**Air Quality Review:**  
West Midlands  
Interchange – additional  
comments

April 2019

<b>Job Number</b>	J3582A
-------------------	--------

Report No.	Date	Status	Reviewed by
J3582A/2/F1	1 April 2019	Final Report	Stephen Moorcroft (Director)

**Table 1 – Model Verification for SSDC**

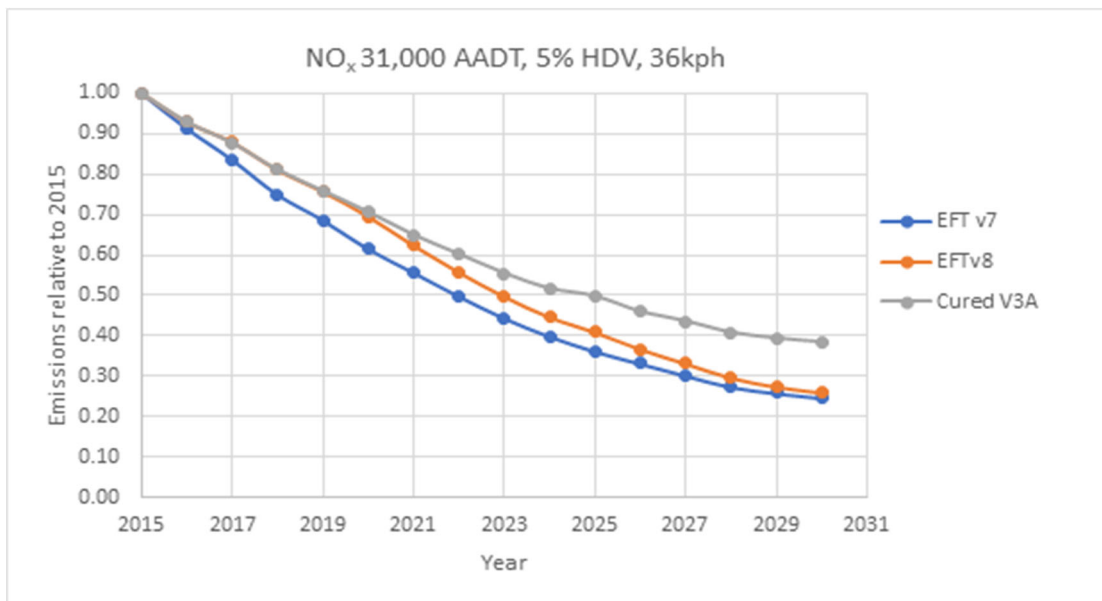
- 2.4 The axes on the graph appear to be incorrectly labelled. Based on the values provided in the accompanying table, it appears that the x-axis actually shows the measured values and the y-axis shows the modelled values. It is not clear if the verification factor derived from this graph has been calculated or applied correctly.

- 2.5 Two near motorway monitoring sites, ES4 and PE have been included in the calculation of the verification factor on the basis that "*whilst influenced by emissions from a motorway, are not particularly close to the motorway*". Whilst these sites do not appear as outliers in the graph, and it probably reasonable to do this, it is not appropriate to apply this verification factor to receptors nearer to motorways as this can lead to large overpredictions in concentrations (as discussed in the next section).
